September 17, 2008

Re: DRB # 1006002 - Mesa del Sol Innovation Park Replat of Tract L
Minor Subdivision Final Plat Approval

CITY OF ALBUQUERQUE
PLANNING DEPARTMENT
August 27, 2008
DRB Comments

RE: Tract L, Mesa Del Sol Innovation Park

PLAT OF
TRACTS L-1 AND L-2
MESA DEL SOL
INNOVATION PARK II
 (A REPLAT OF TRACT L
 MESA DEL SOL INNOVATION PARK II)
 ALBUQUERQUE, BERNALILLO COUNTY, NEW MEXICO
 AUGUST, 2008

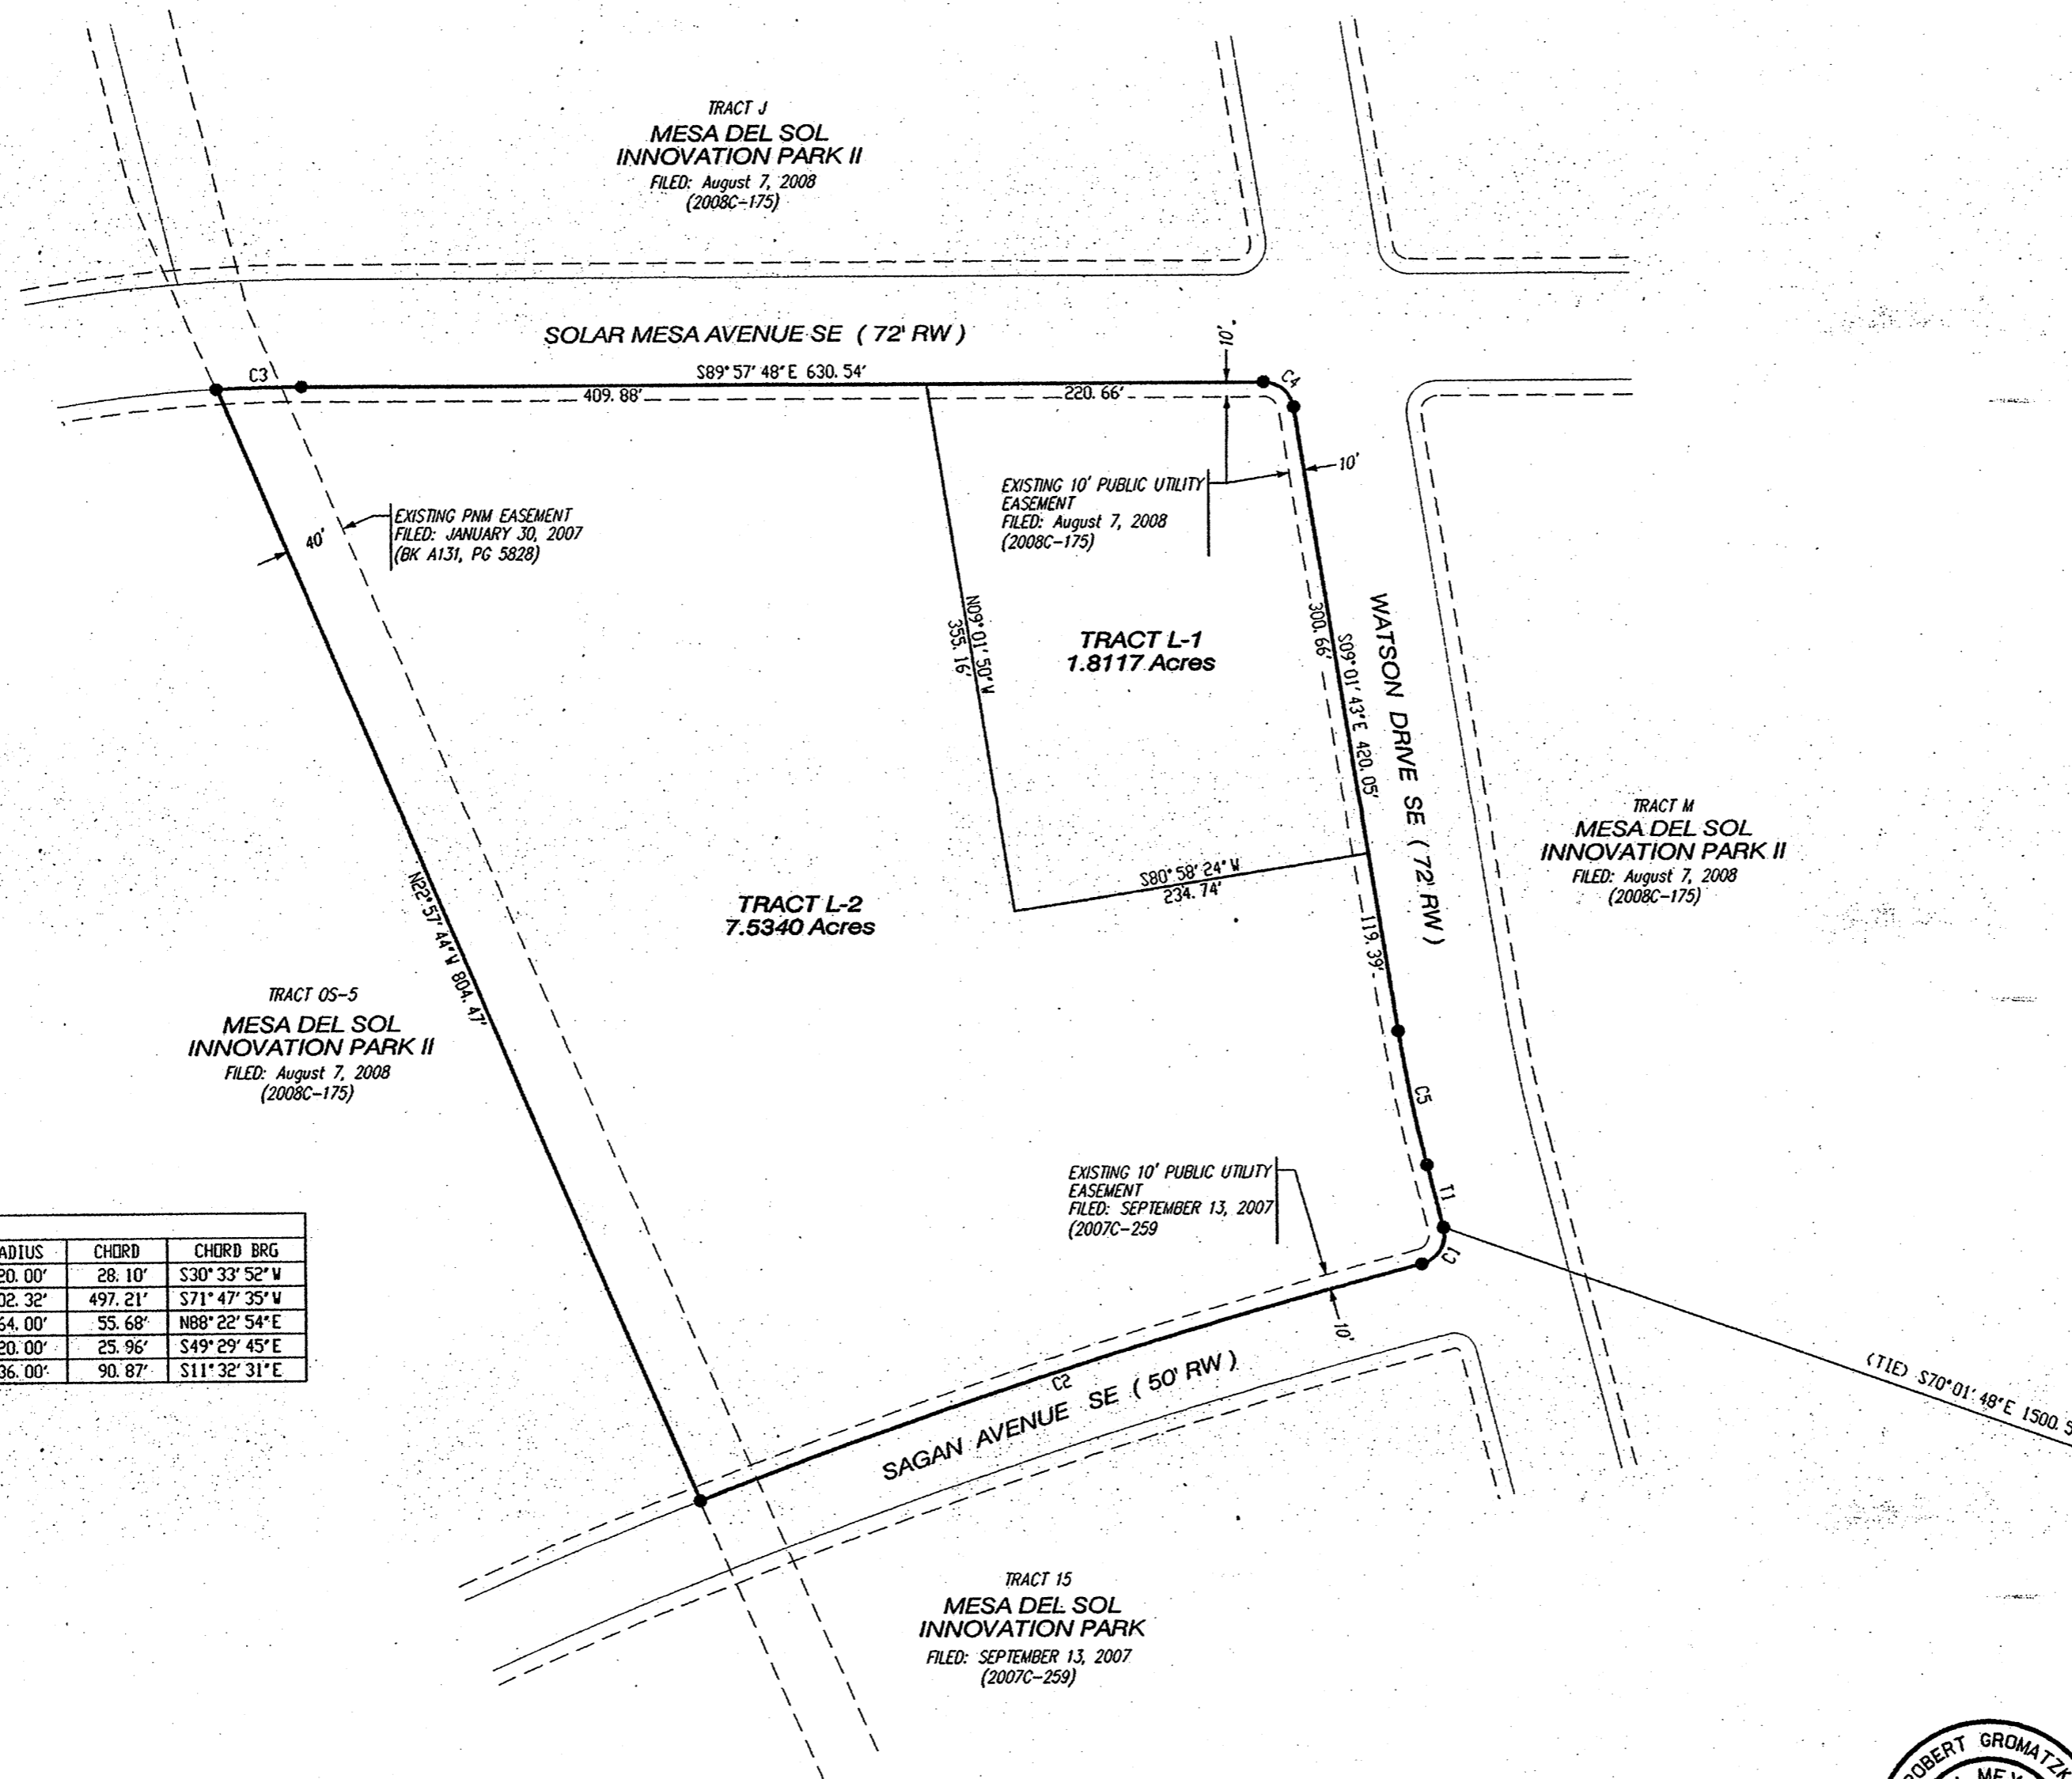
Please provide a site development plan to justify proposed lot lines – it appears reciprocal access and drainage easements may be needed.

Comment on infrastructure list.
Need cross-lot drainage easement on plat.
An executed Subdivision Improvements Agreement with Financial Guarantees is required for Final Plat approval.
